From: Darren Shaw [REDACTED]
Sent: 26 February 2019 16:50
To: Stuart Corbey
Cc: Keith Hurdley; Amanda Farley; Lauren Ballam
Subject: FW: Application FP/263/18/PI - Timberely, The Ridgway

From: Darren Shaw [REDACTED]
Sent: 06 February 2019 11:25
To: Richard Castro-Parker
Cc: Amanda Farley
Subject: Application FP/263/18/PI - Timberely, The Ridgway

PROPOSED DWELLING
ELEVATIONS

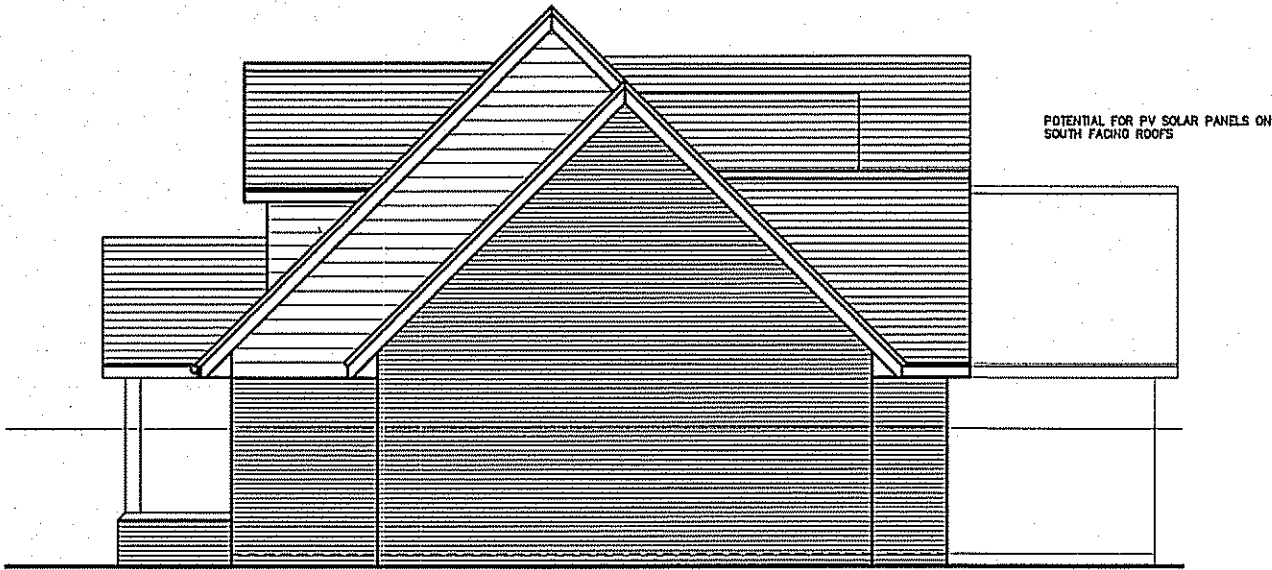
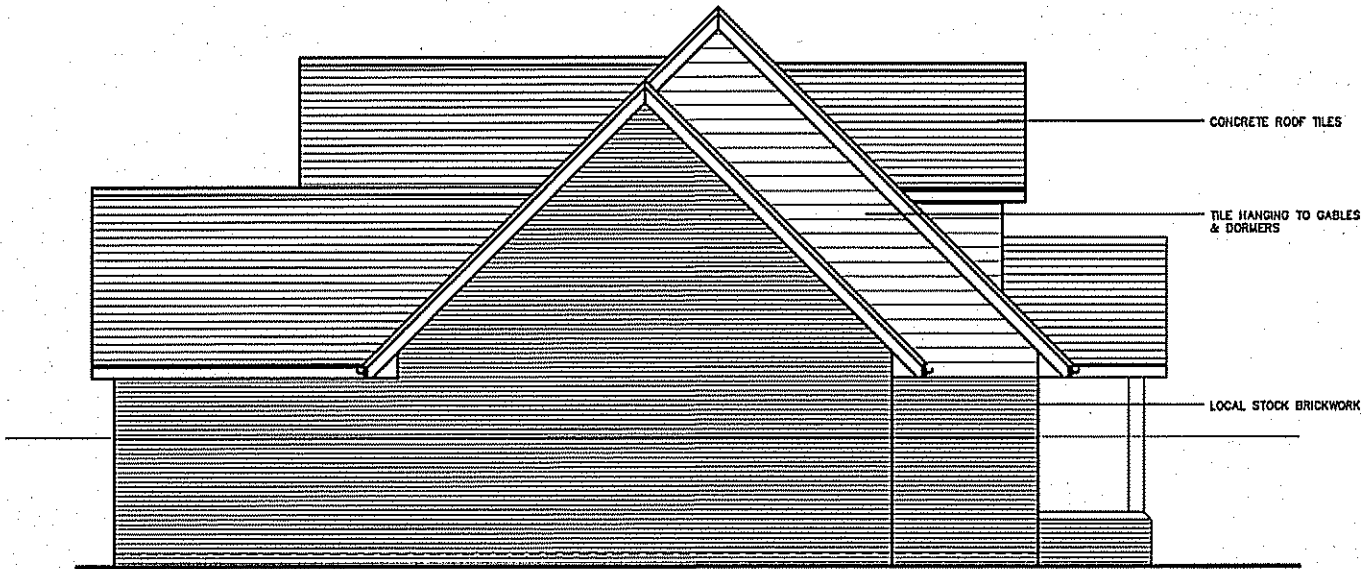
Our client has confirmed that he intends to use a Freshfield Lane 'Danehill Yellow' brick for the external walls as per the attached spec sheet. This has a very similar appearance to the bricks used by the property opposite 'Timberely', across the green. An exact roof tile has not been selected as yet but this will be a small format, concrete tile in a slate grey colour very similar to that which has been used on the recent renovation of the immediate neighbour to the North of our site (Fleet Cottage).

SIDE / SOUTH FACING ELEVATION SHOWING PROPOSED BRICK WALL

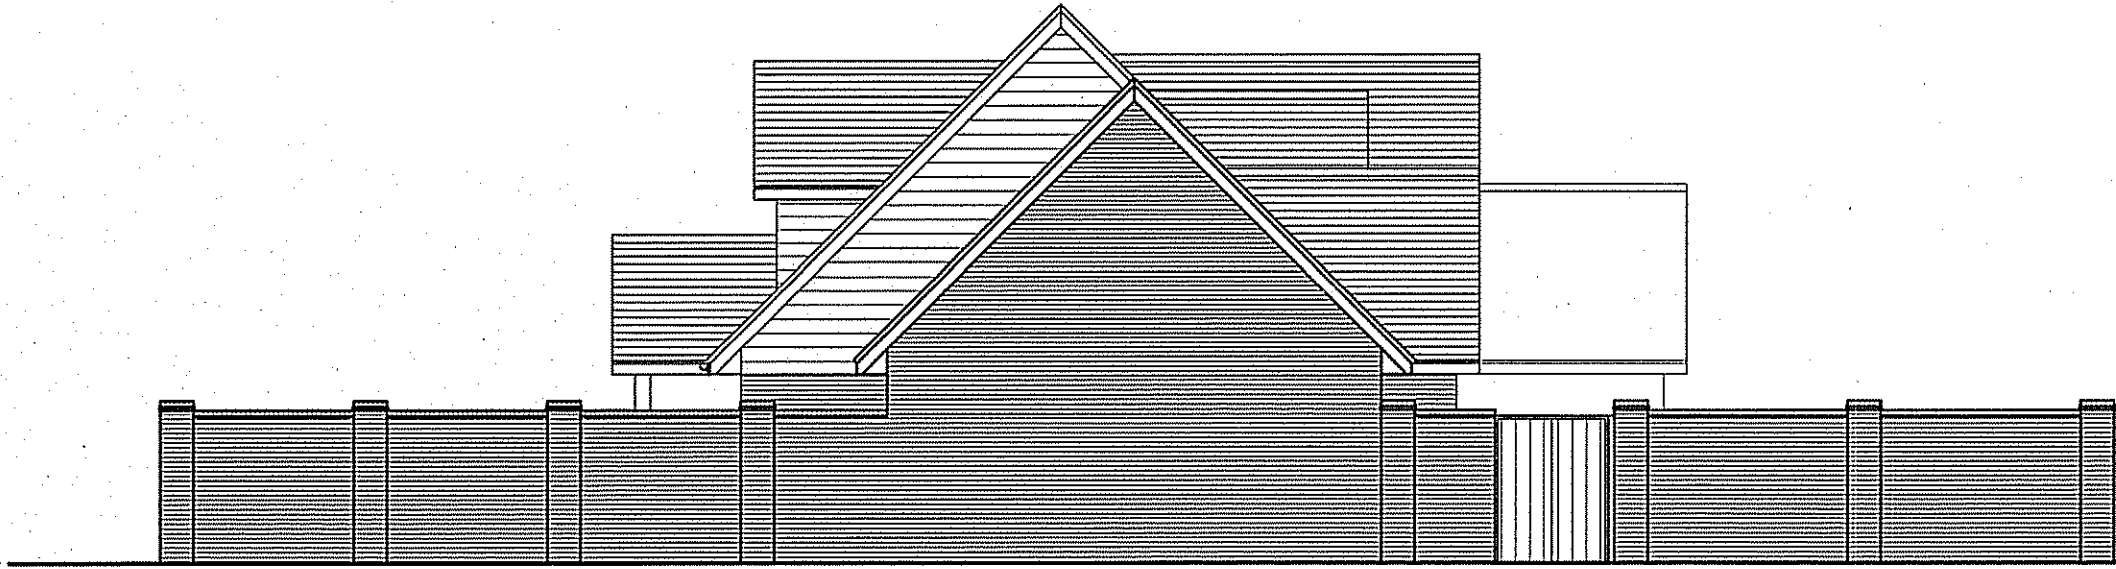
1. The boundary hedge/new boundary wall
2. External materials

As per our conversation yesterday and the details submitted, our client definitely intends to remove the overgrown, unkept hedge on the South boundary. Being a private estate, our client has spoken to the Estate Manager regarding this and they have no concerns with its removal. The hedge is not protected and our client already has its removal planned by certified tree surgeons in the coming weeks. As I also highlighted to you yesterday when we spoke, the only comment received on the application is from the residents of 34 Minton Road (who own the garage behind our client's plot) and will face the side of the new property and they have no concerns with the removal of the privet hedge and also allude to its overgrown state. I believe you also stated that this new boundary could be constructed under PD rights in any case.
